WEST SUSSEX COUNTY COUNCIL CONSULTATION

TO:	Arun District Council FAO: David Spring
FROM:	WSCC - Highways Authority
DATE:	9 March 2020
LOCATION:	Rear of Rookery Farm 113 North Bersted Street Bersted PO22 9AG
SUBJECT:	BE/16/20/PL Demolition of storage buildings & erection of 1 No 3-bed cottage. This application affects the setting of listed buildings & affects the character & appearance of the North Bersted Conservation Area.
DATE OF SITE VISIT:	n/a
RECOMMENDATION:	Modification
S106 CONTRIBUTION TOTAL:	n/a

Drawing 3 - Proposed Site Plan

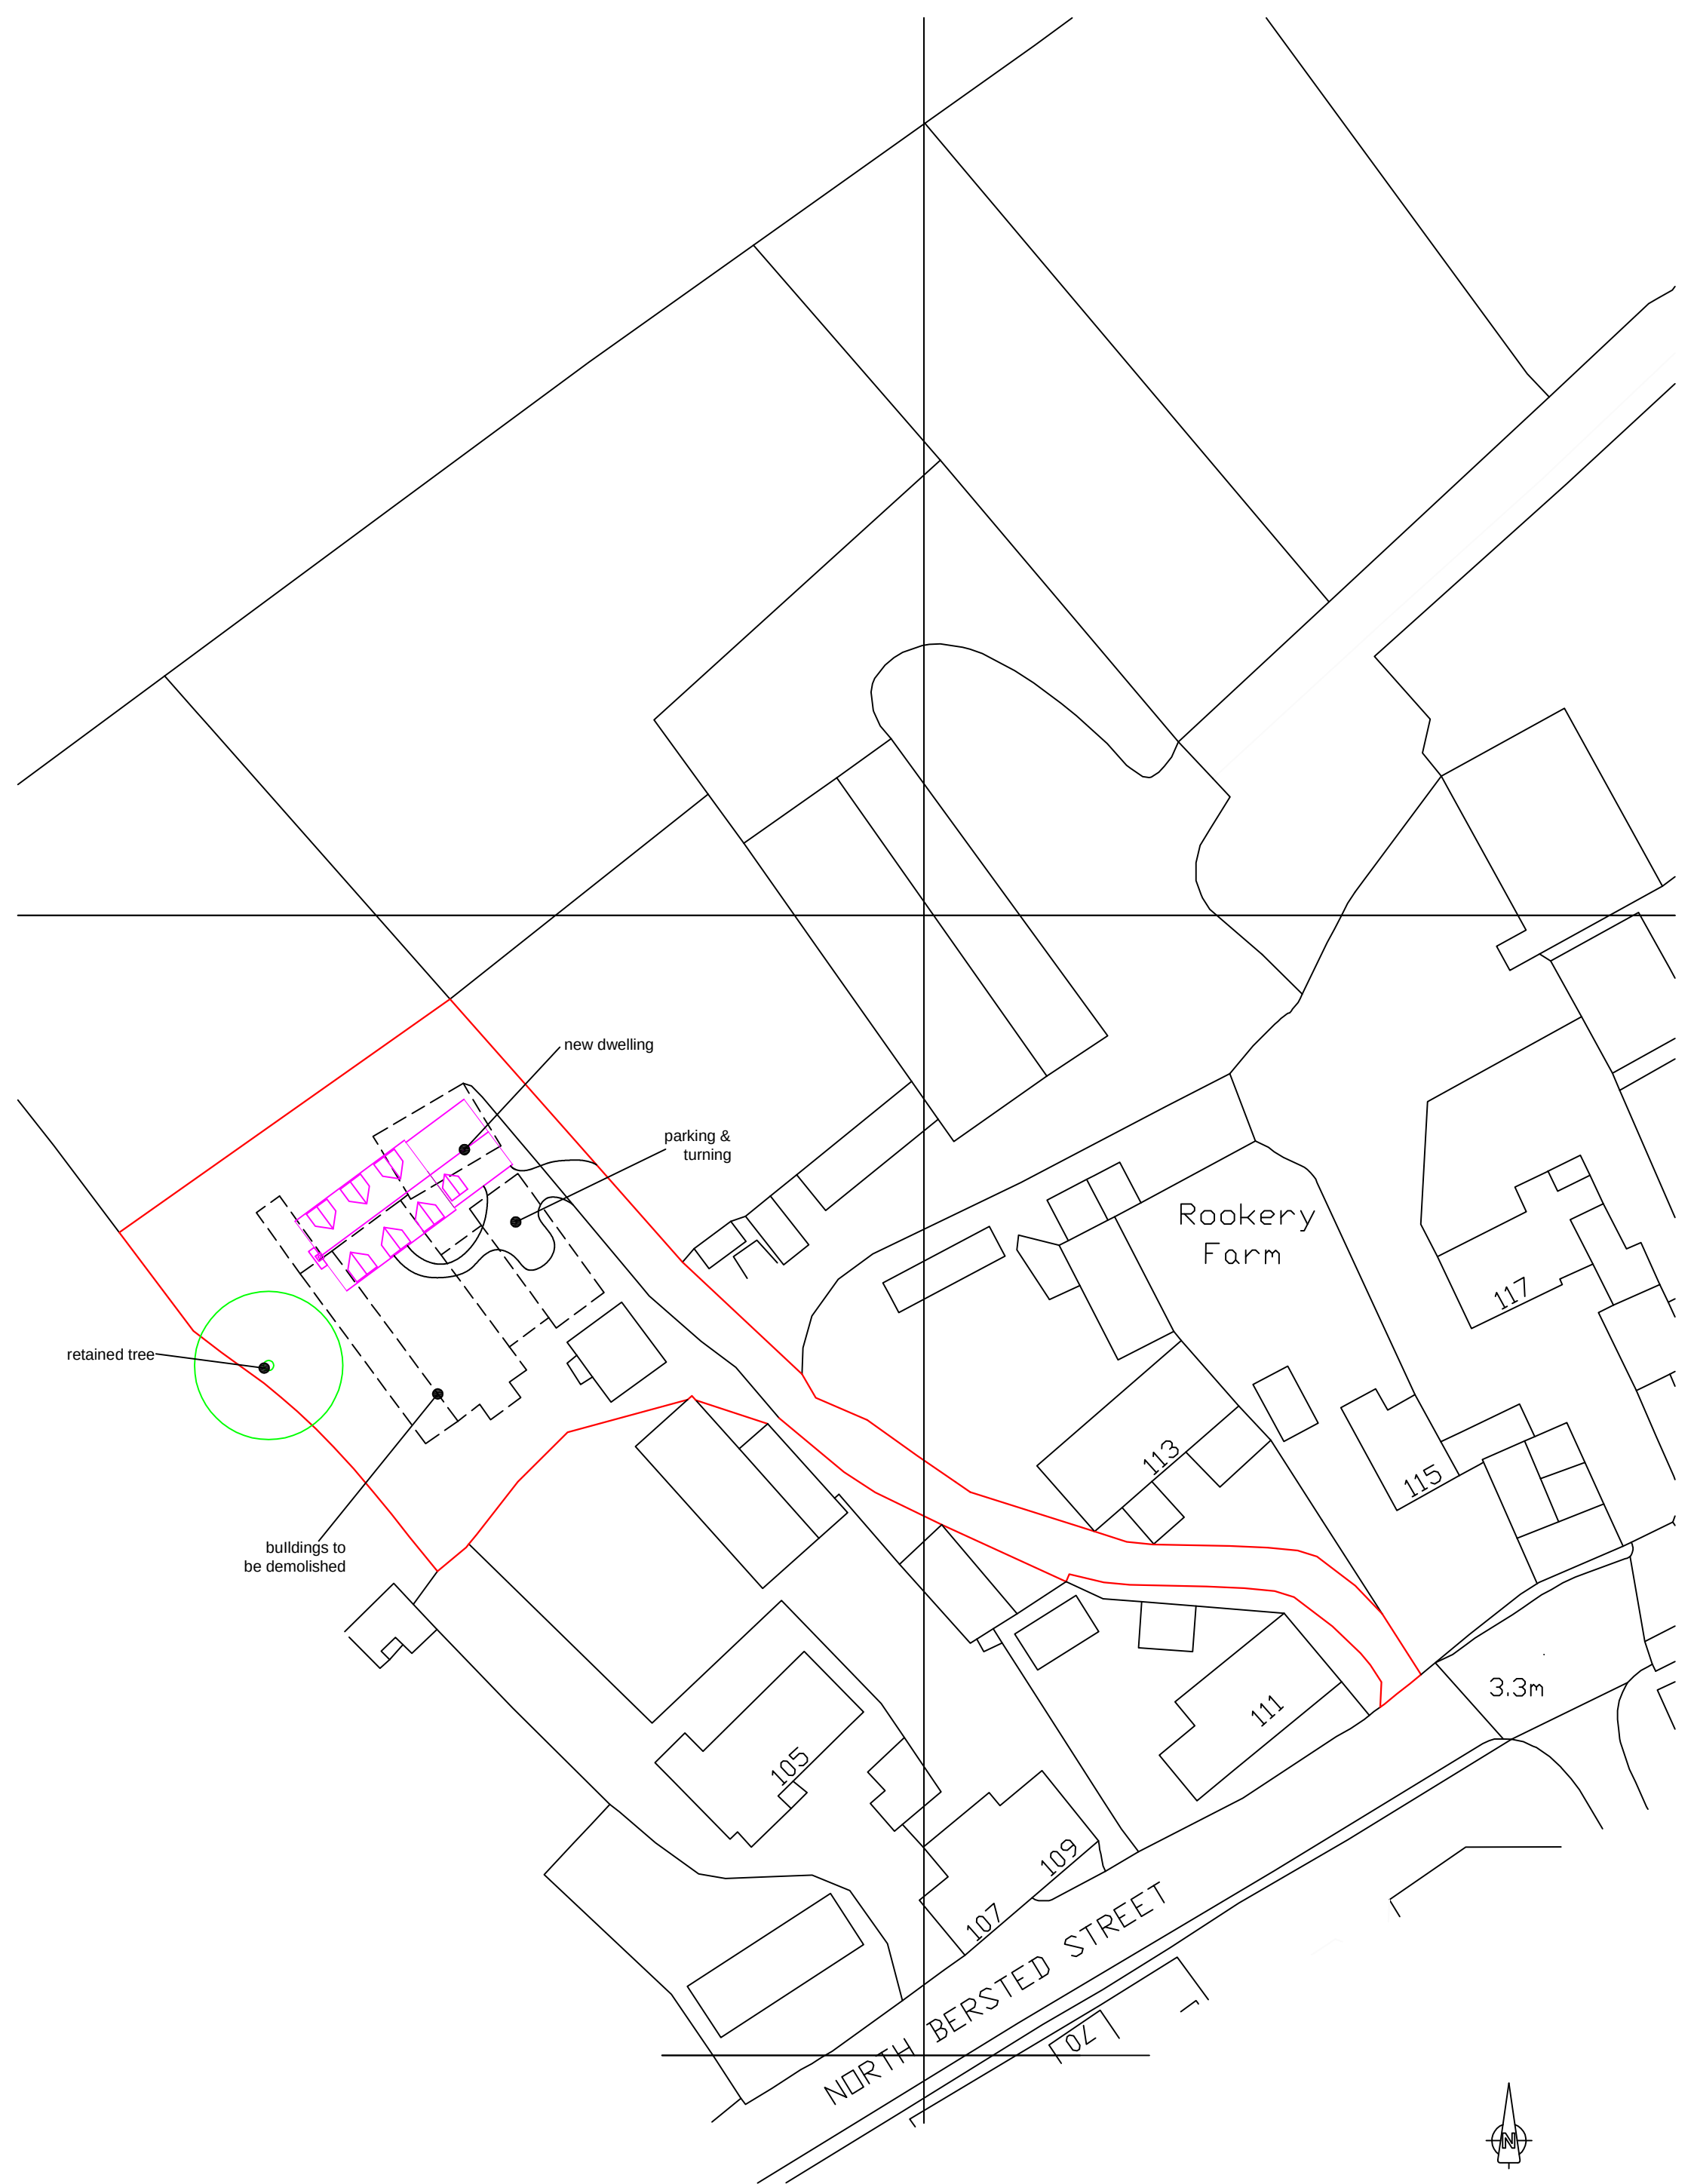
The applicant has not clearly demonstrated parking and turning within the site. The applicant should be aware that a single parking space must measure 2.4x4.8 metres as outlined in Manual for Streets Guidance (MfS).

The applicant has proposed a nil cycle parking provision, as per Arun Parking Standards (adopted January 2020) we wish to see cycle storage implemented in the form of lockable covered storage.

In principle the Local Highways Authority (LHA) does not consider that this proposal would have an unacceptable impact on highway safety or result in 'severe' cumulative impacts on the operation of the highway network. However, the LHA require a modification regarding the Parking and Turning provisions, as described above.
